Application No: BR/65/25/PL

Reason for the Update / Changes

LOCATION: New Barn Garage
65-67 Aldwick Road
Bognor Regis
PO21 2NW

PROPOSAL: Change of use of existing car showroom to a self-storage unit, including the change of use of an attached ground-floor retail unit to associated office space. Extension and replacement of the existing showroom warehouse building to incorporate a first-floor and conversion of existing rear single storey extension, of the main warehouse building, to additional office space. This application is in CIL Zone 4 (Zero Rated) as other development.

Existing Section a - a

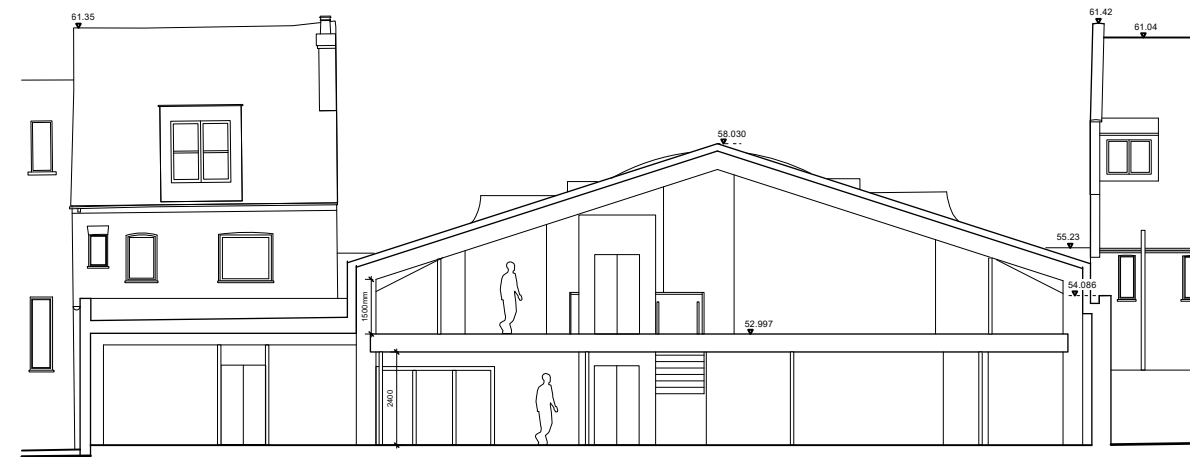
The proposal involves new profiled aluminium roof and would increase the height of the main warehouse by an approx. 0.9m at both ridge and eaves to allow an additional storey. The footprint will remain the same, and overall, the bulk of the building will not increase unacceptably.

The proposal includes raising the building's ridge and eaves height by approximately 0.9m. Due to surrounding development, this will have minimal impact on nearby residential properties, except for the rear garden of 63A Aldwick Road. This south-facing garden is deep and already bordered by the existing building which is 3.8m-high. While the height increase is noticeable, it would not cause unacceptable overshadowing or overbearing effects.
